DECISION DELEGATED TO HEAD OF PLANNING

Application No: H20-0274-25 **Applicant:** Mr & Mrs Parsons
Proposal: Single storey rear extension & detached garage to existing dwelling
Location: Field View Old Fendyke Sutton St James
Terminal Date: 5th June 2025

PROPOSED GARAGE

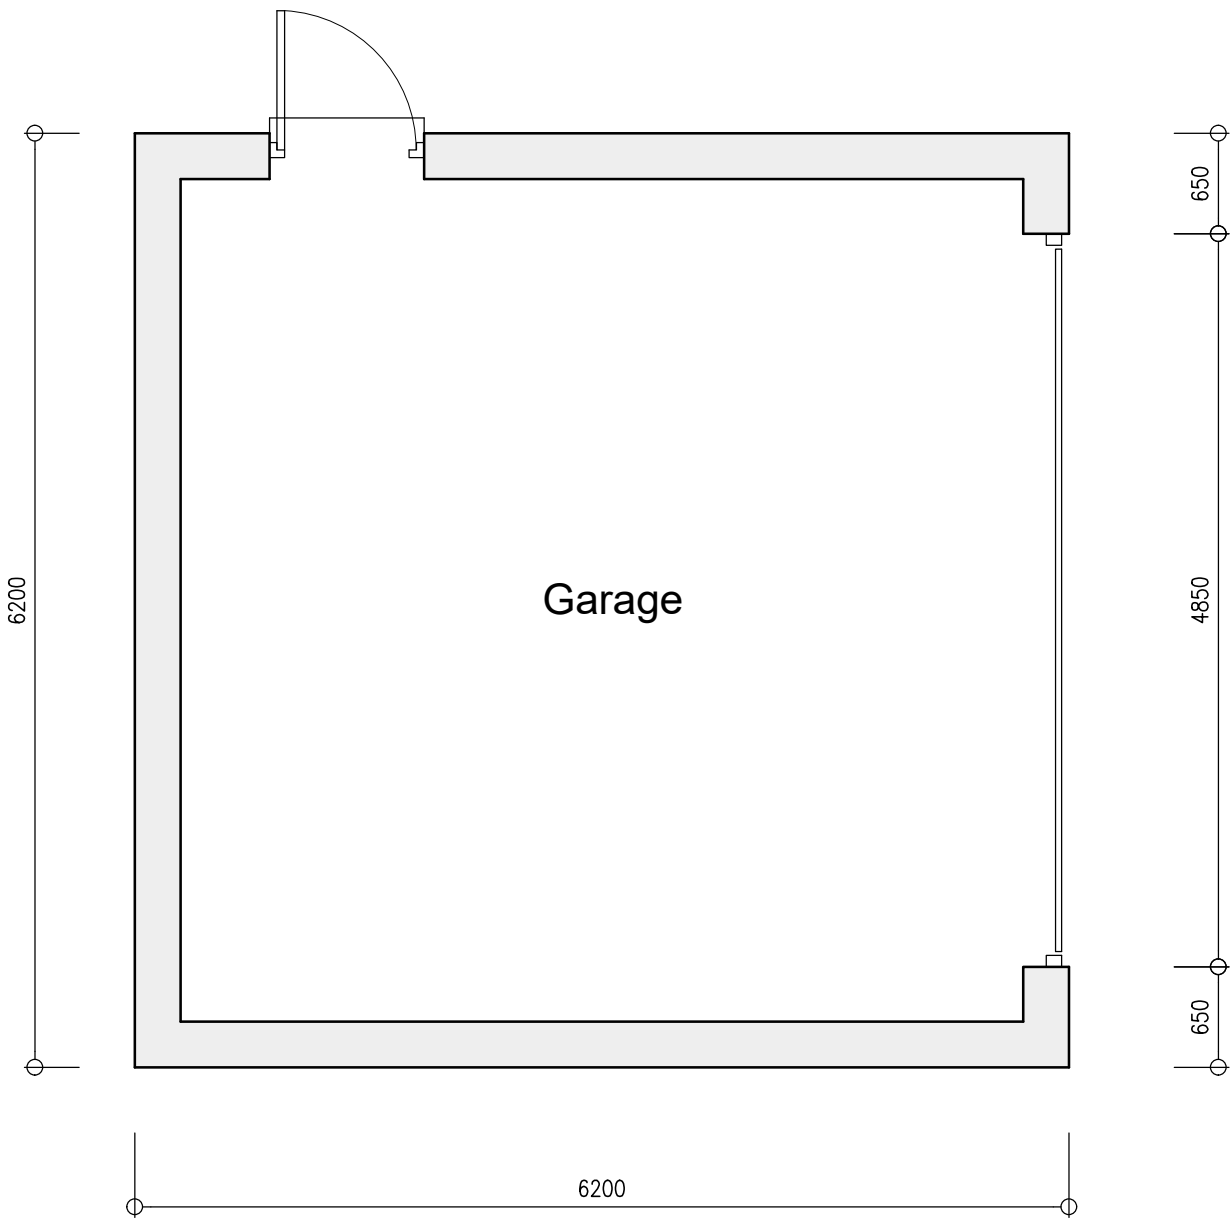
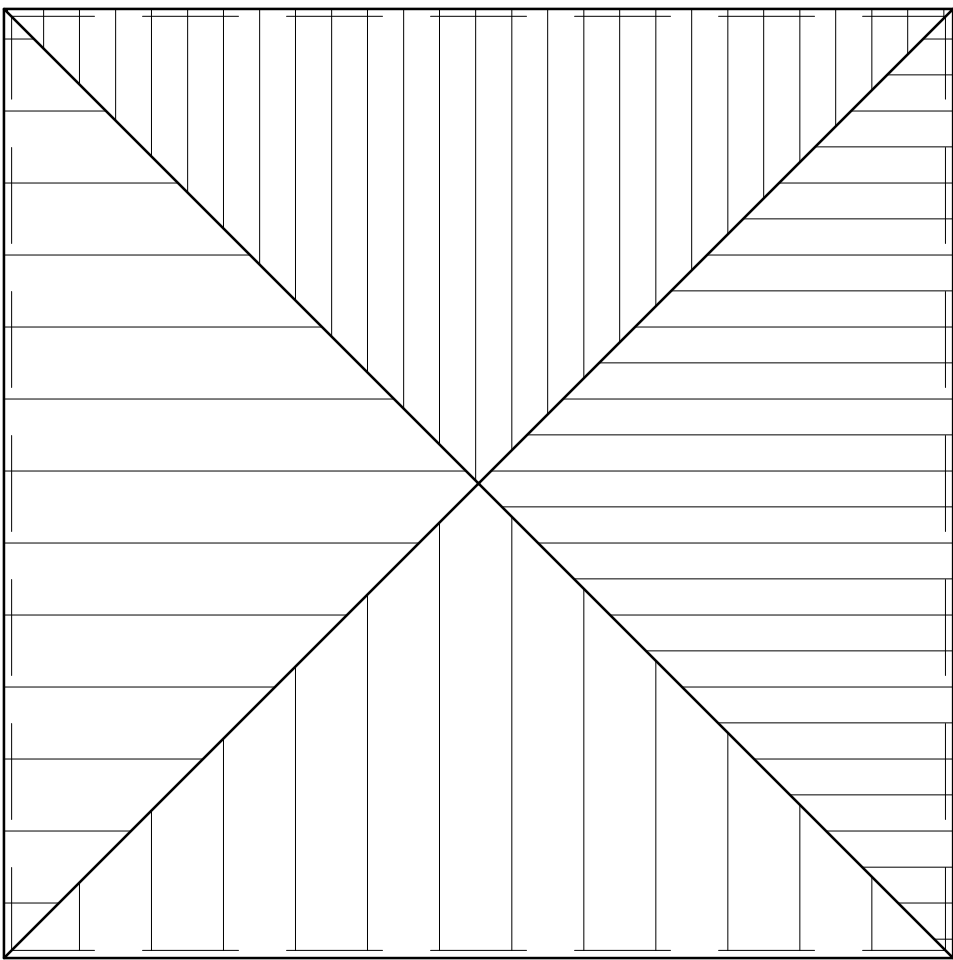
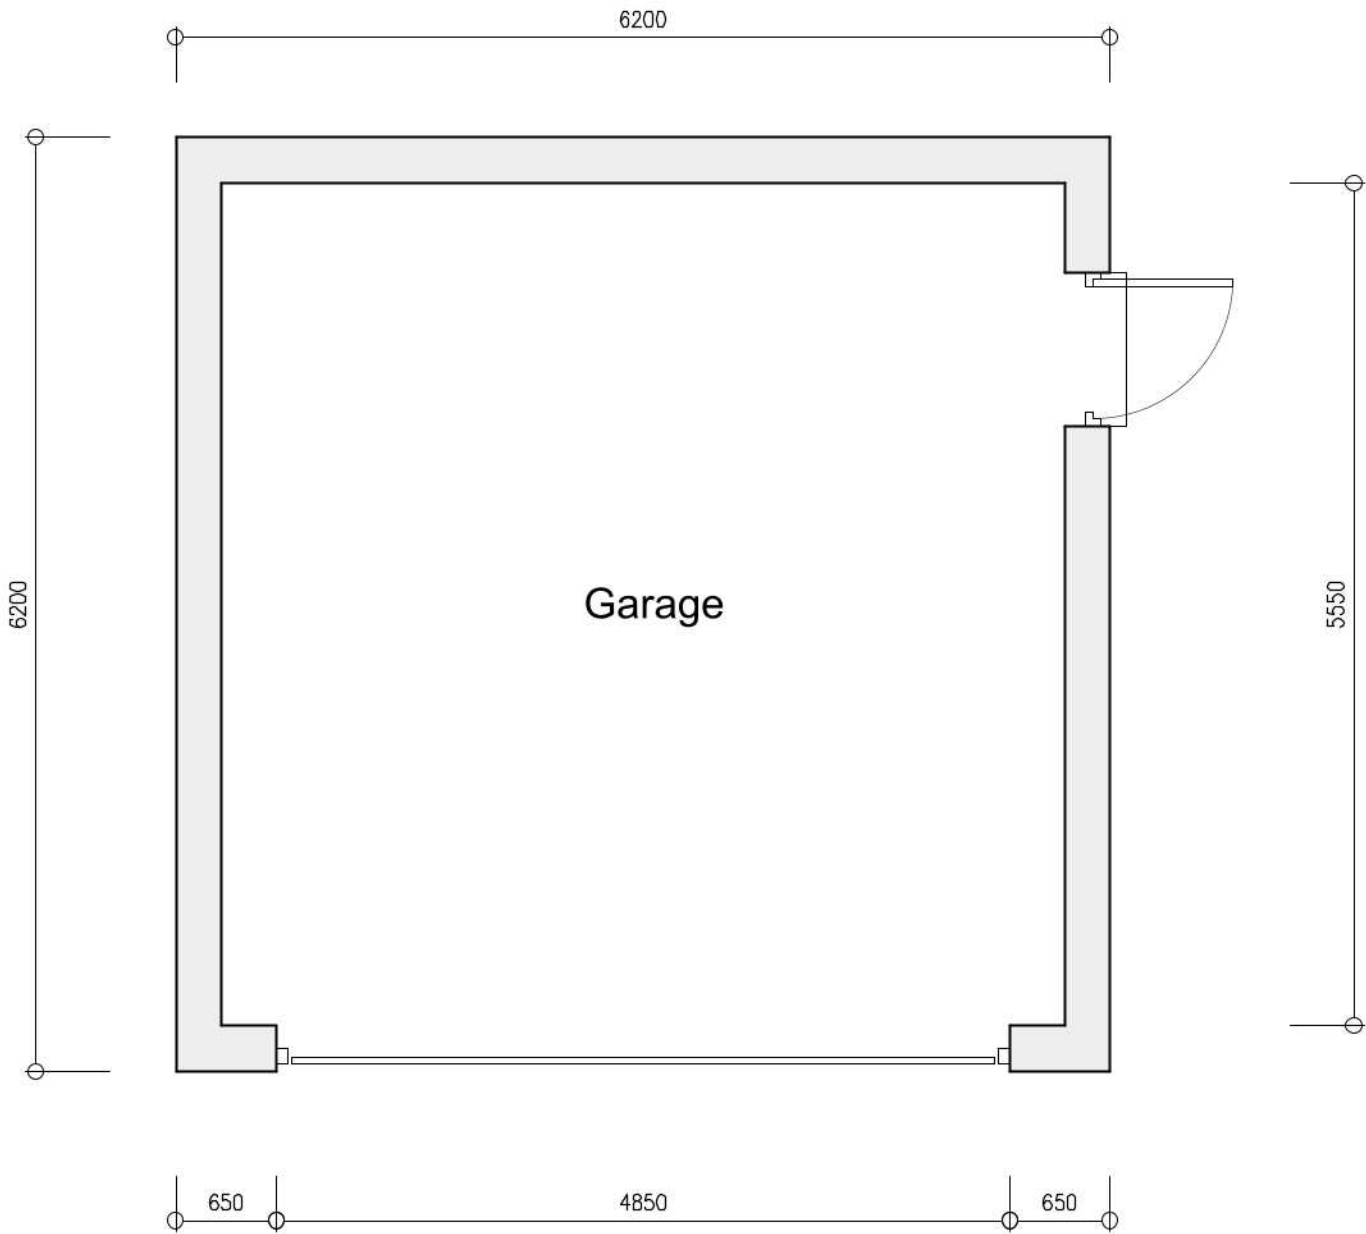
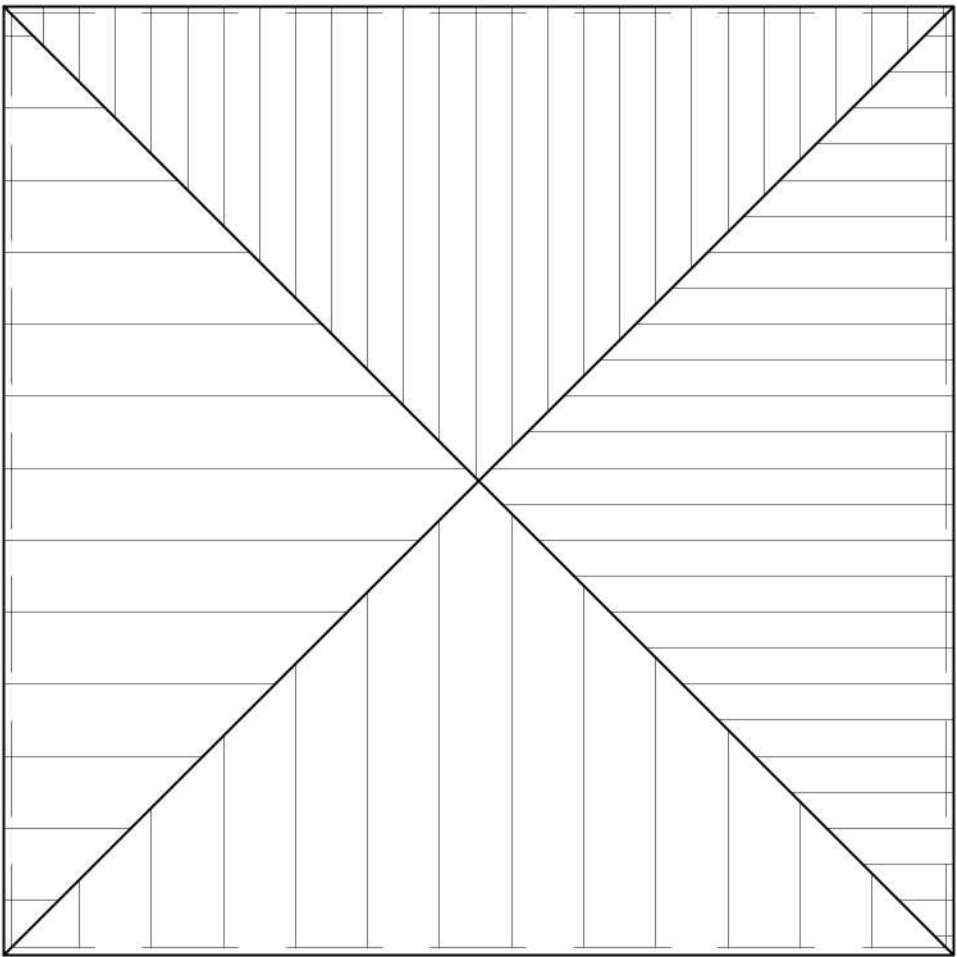
The proposal has been amended throughout the course of the application. The original submission comprised the location of the garage being forward on the front elevation of the dwelling. The garage has now been relocated to the side of the existing dwelling resulting in a more acceptable design.
